## **Oxfordshire County Council's response to Cherwell District Council's consultation on Phase One North West Bicester Eco-town (application: 10/01780/HYBRID)**

Daniel Round  
Linda Currie  
03.02.2011

Figure 3 – Bridge 1 & 2 Design Drawings

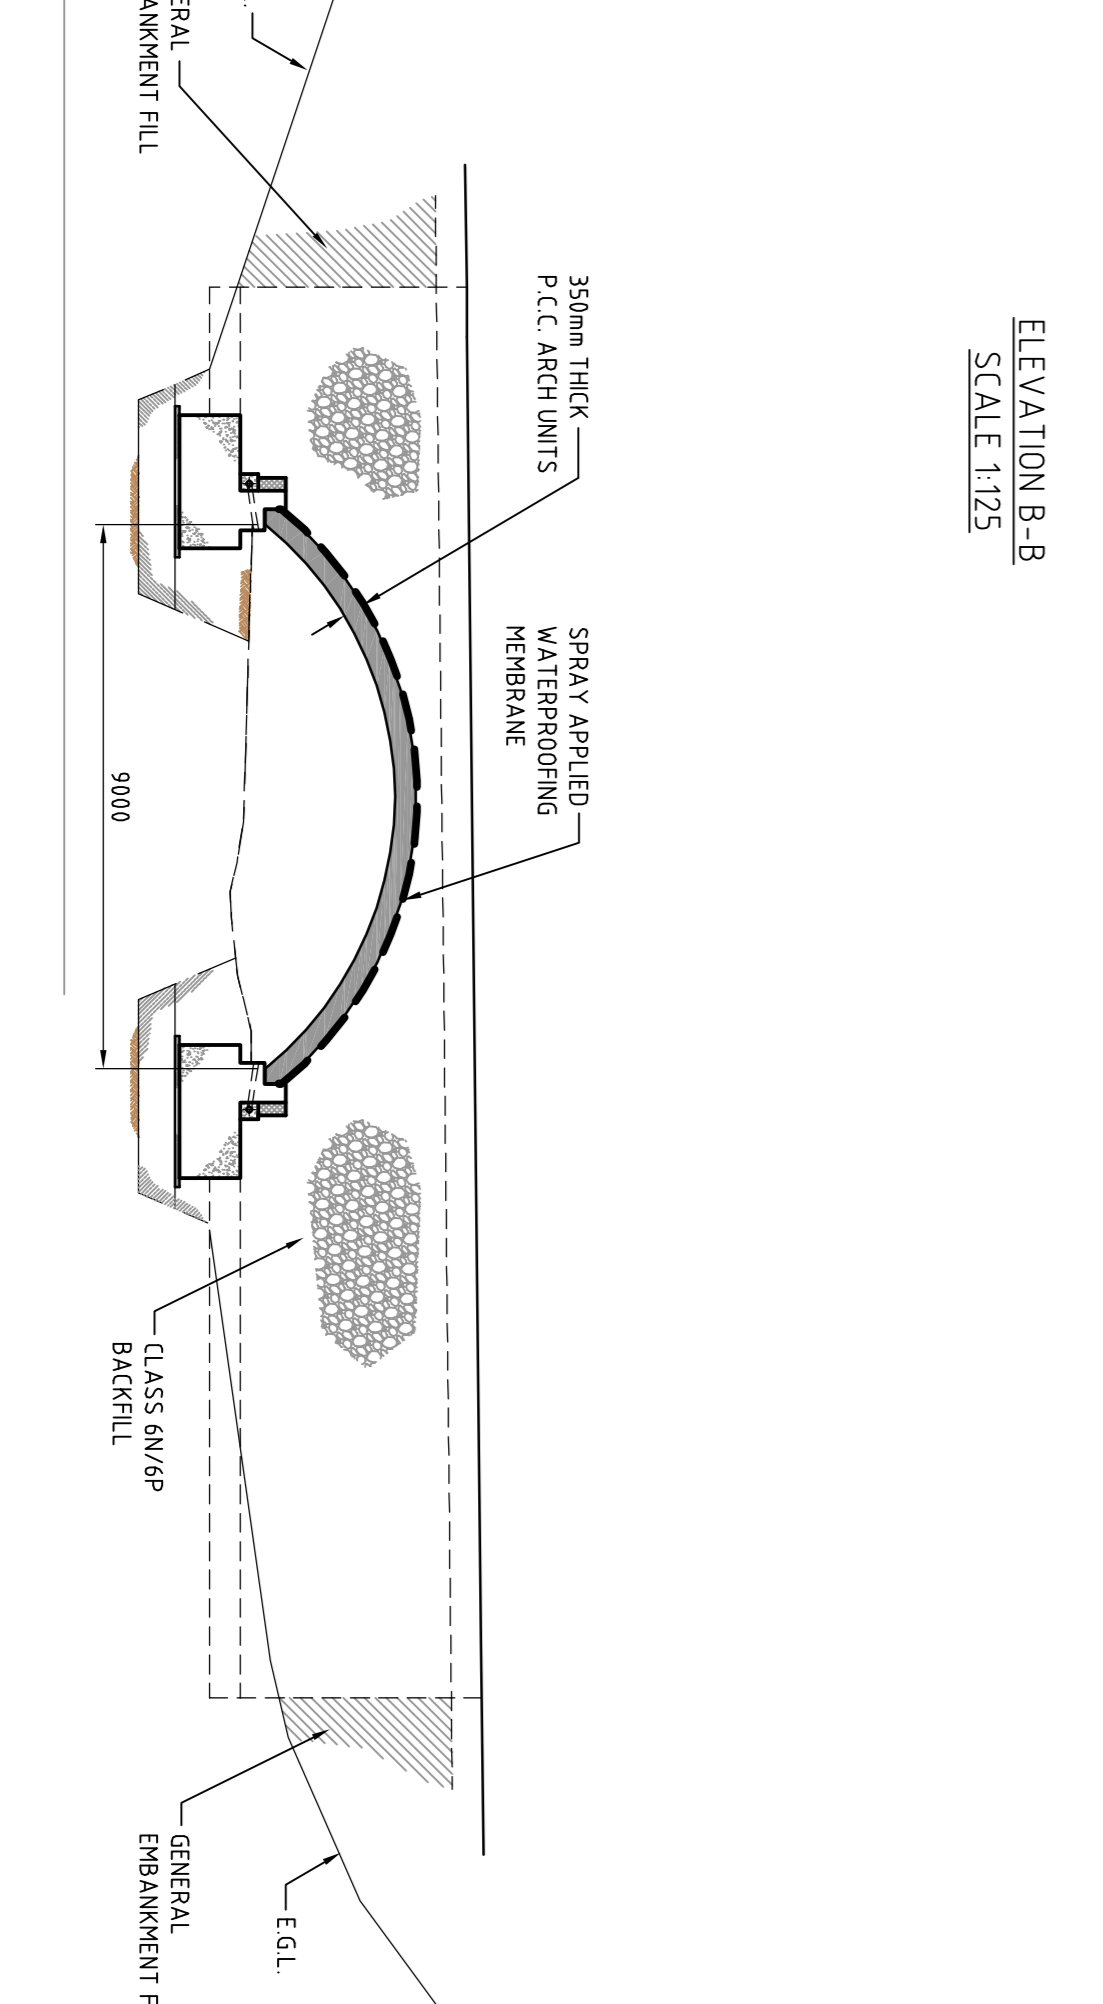
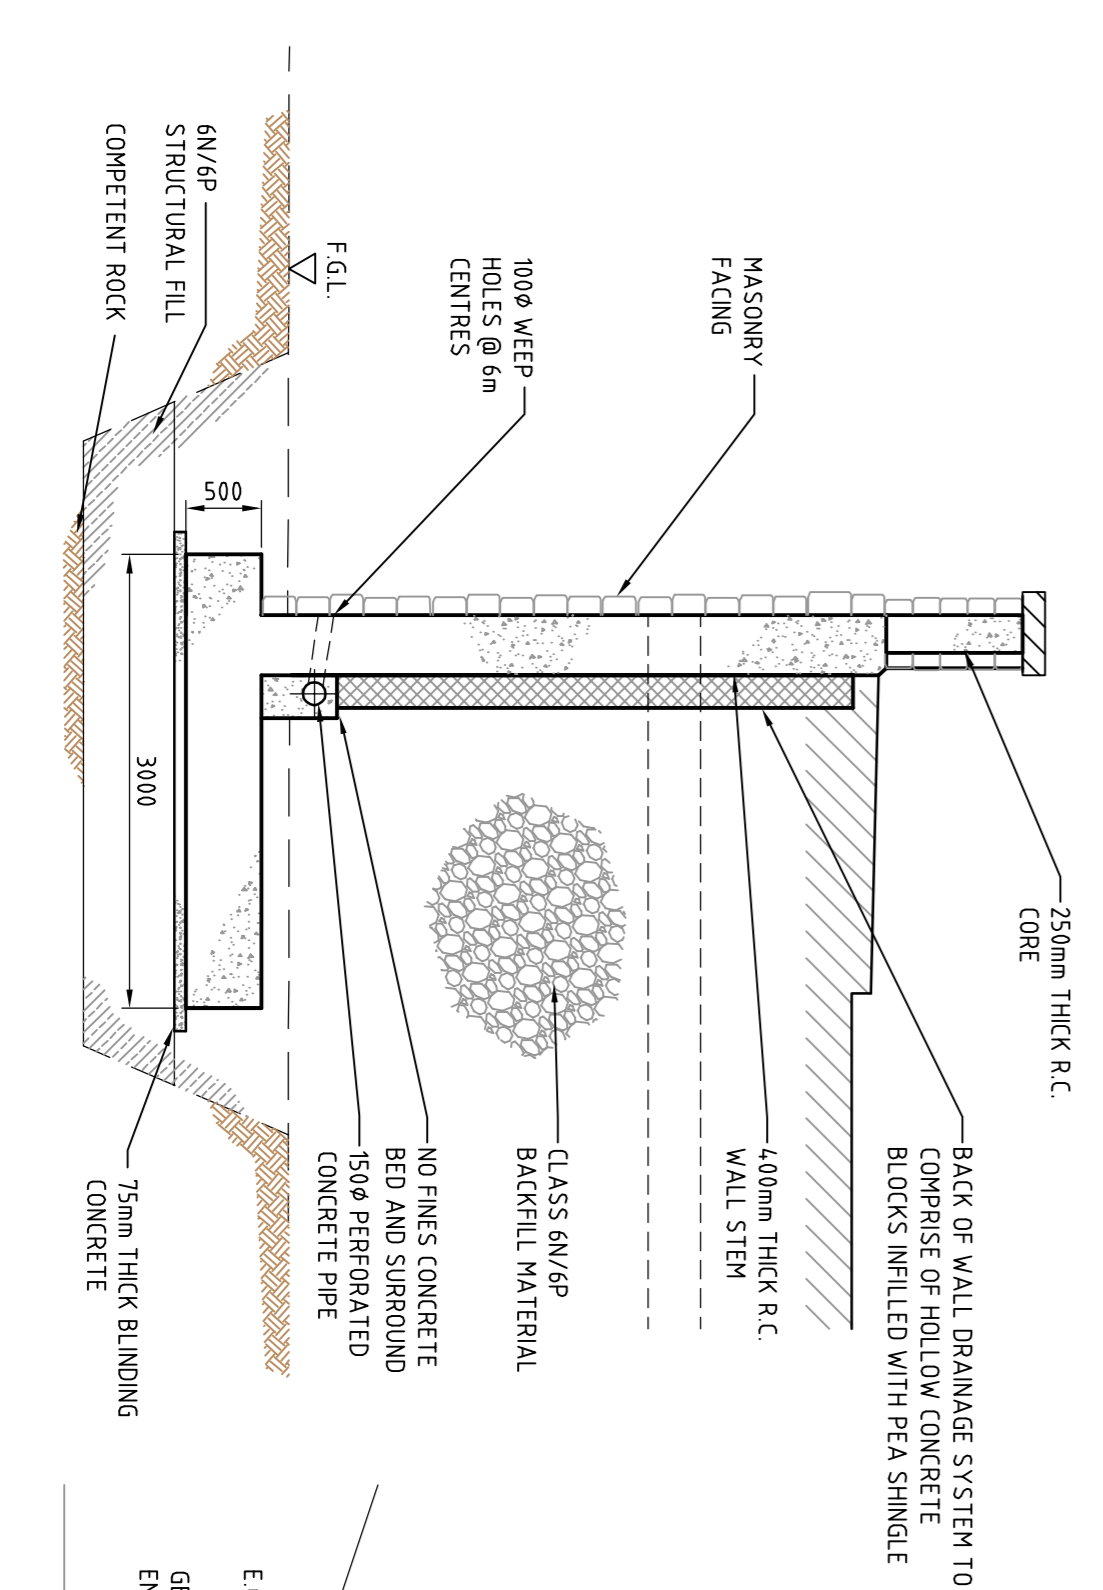
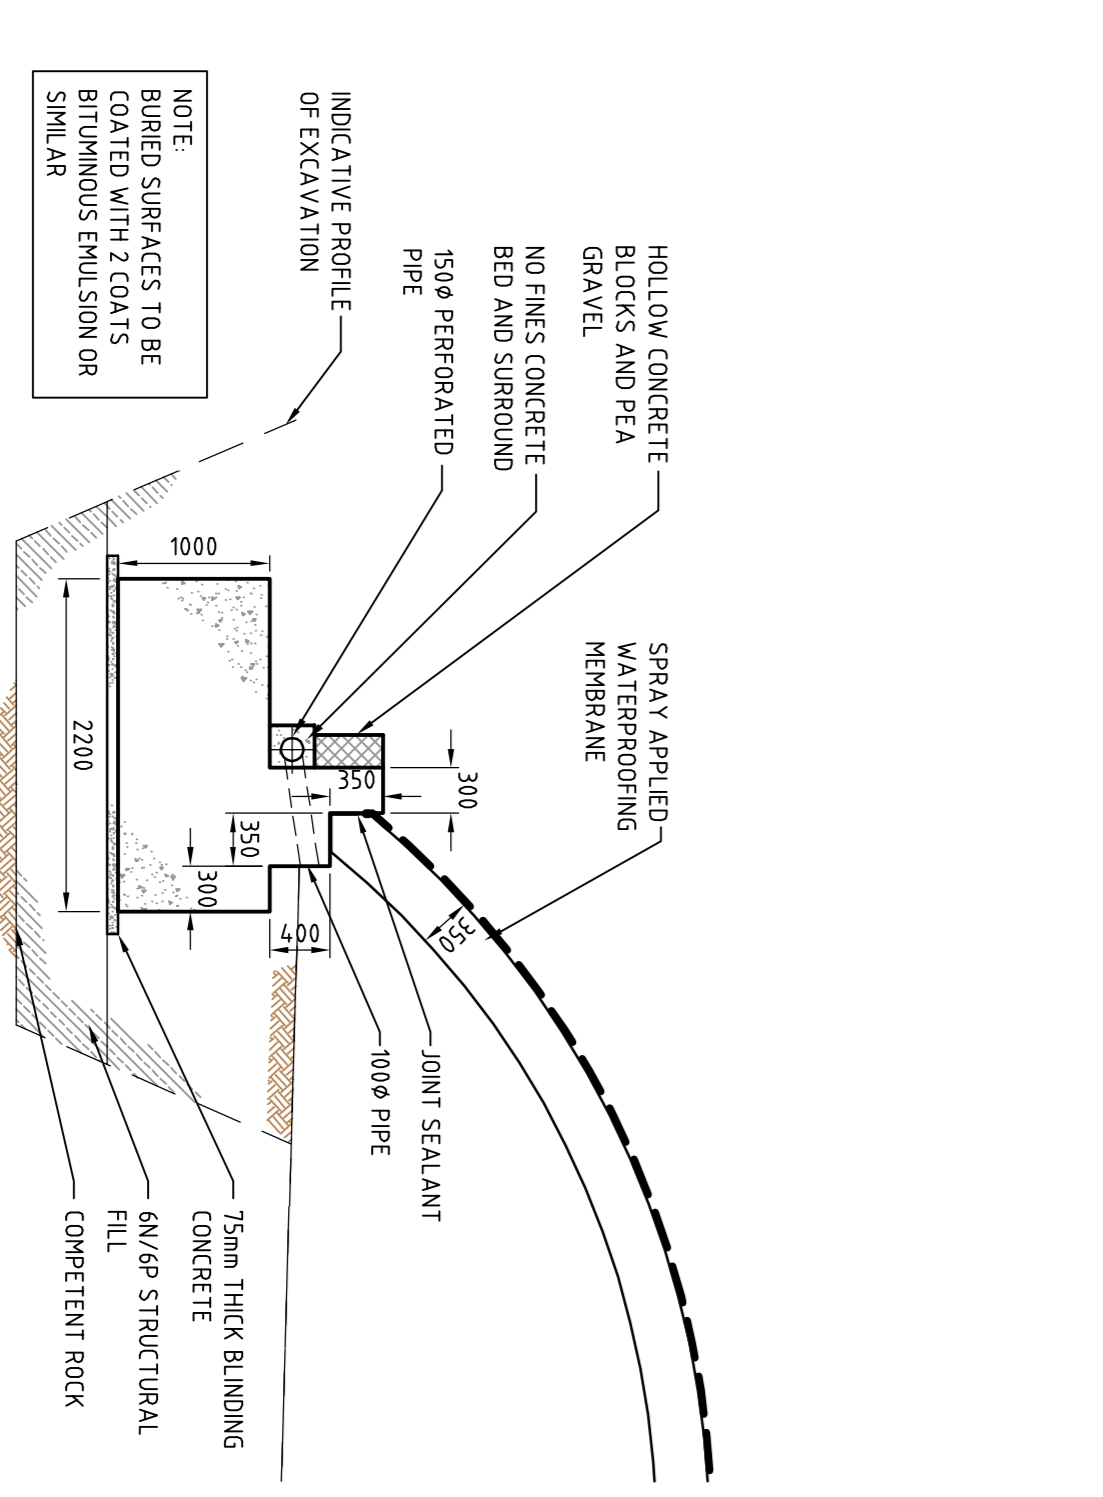
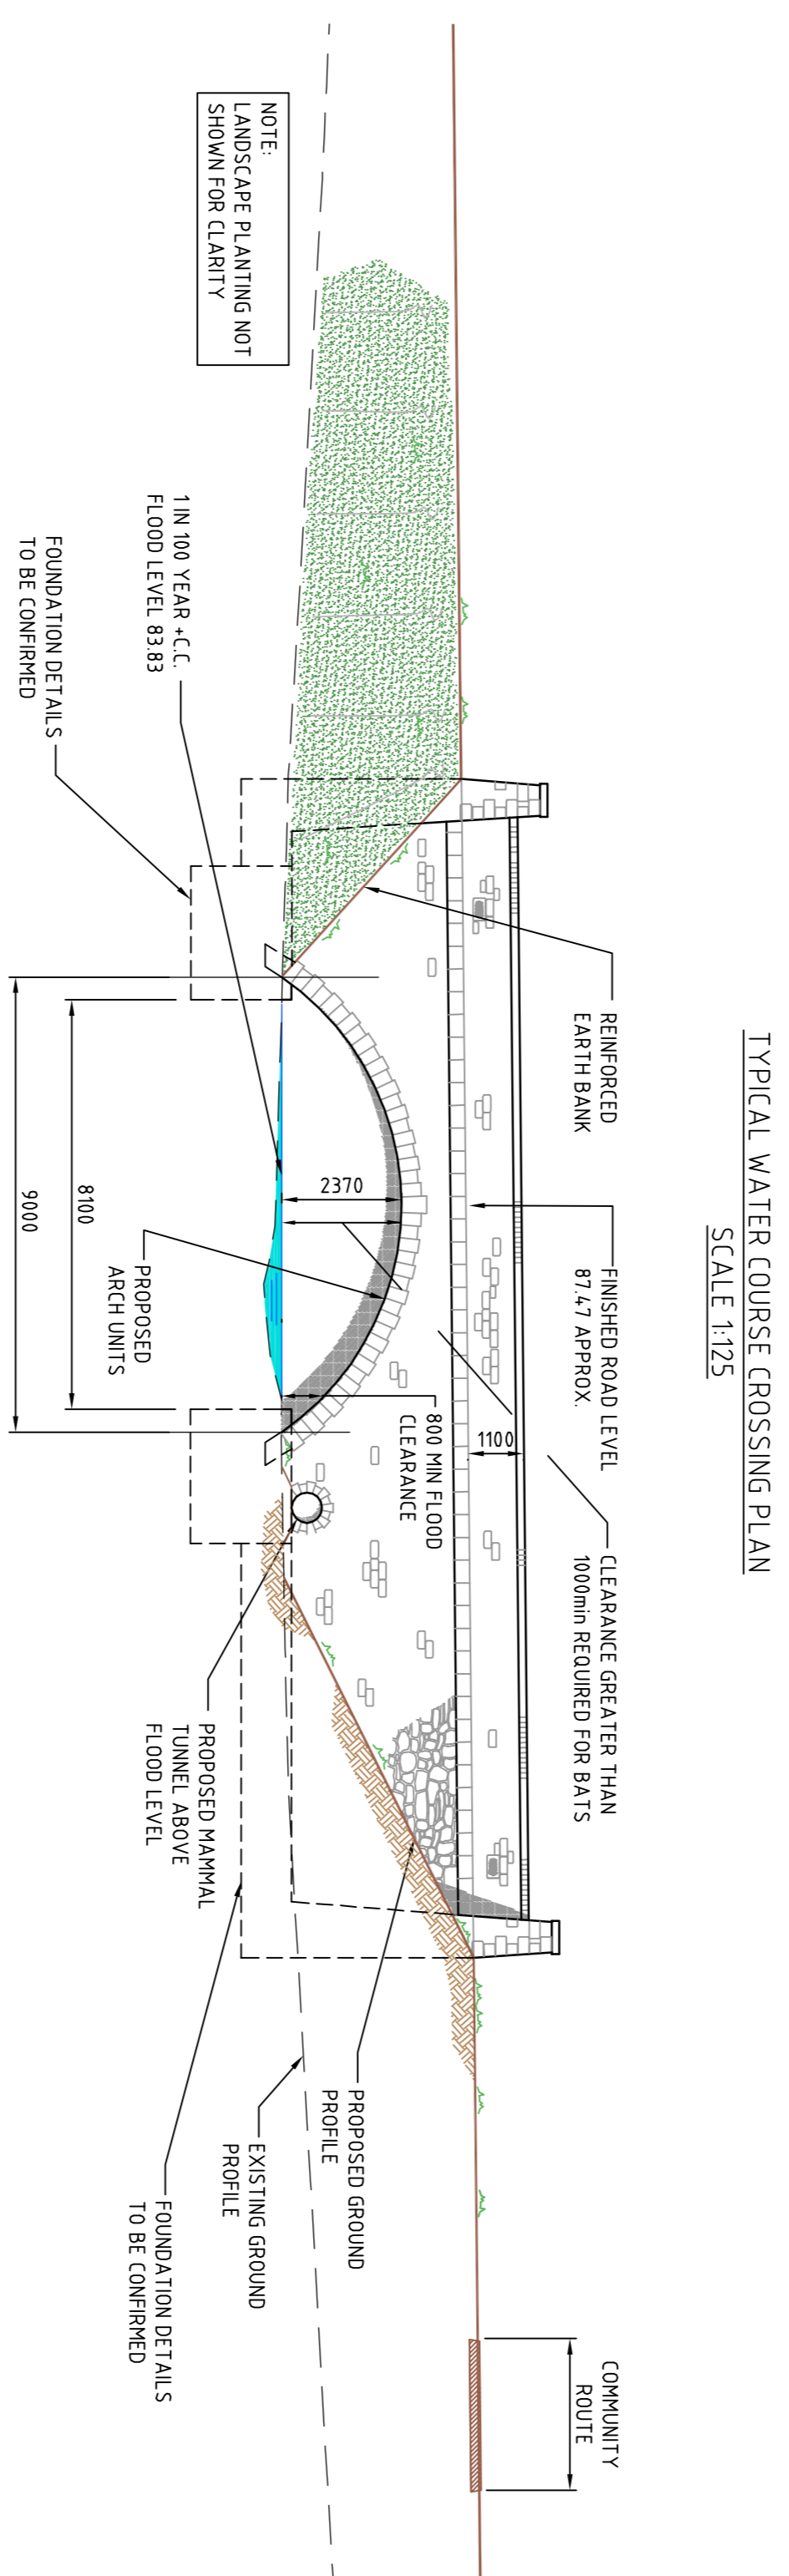
24. The two bridges proposed within the site appear to be structurally sound, but the functional appearance is a missed opportunity to create an architectural statement that is exemplary in its design. Further details are required before “Approved In Principle” (AIPs) plans can be issued for their implementation. This must be a planning condition imposed by CDC.

25. **Recommendation: SUPPORT** subject to adequate information being submitted in order for AIPs to be issued and discharge of an appropriate planning condition.
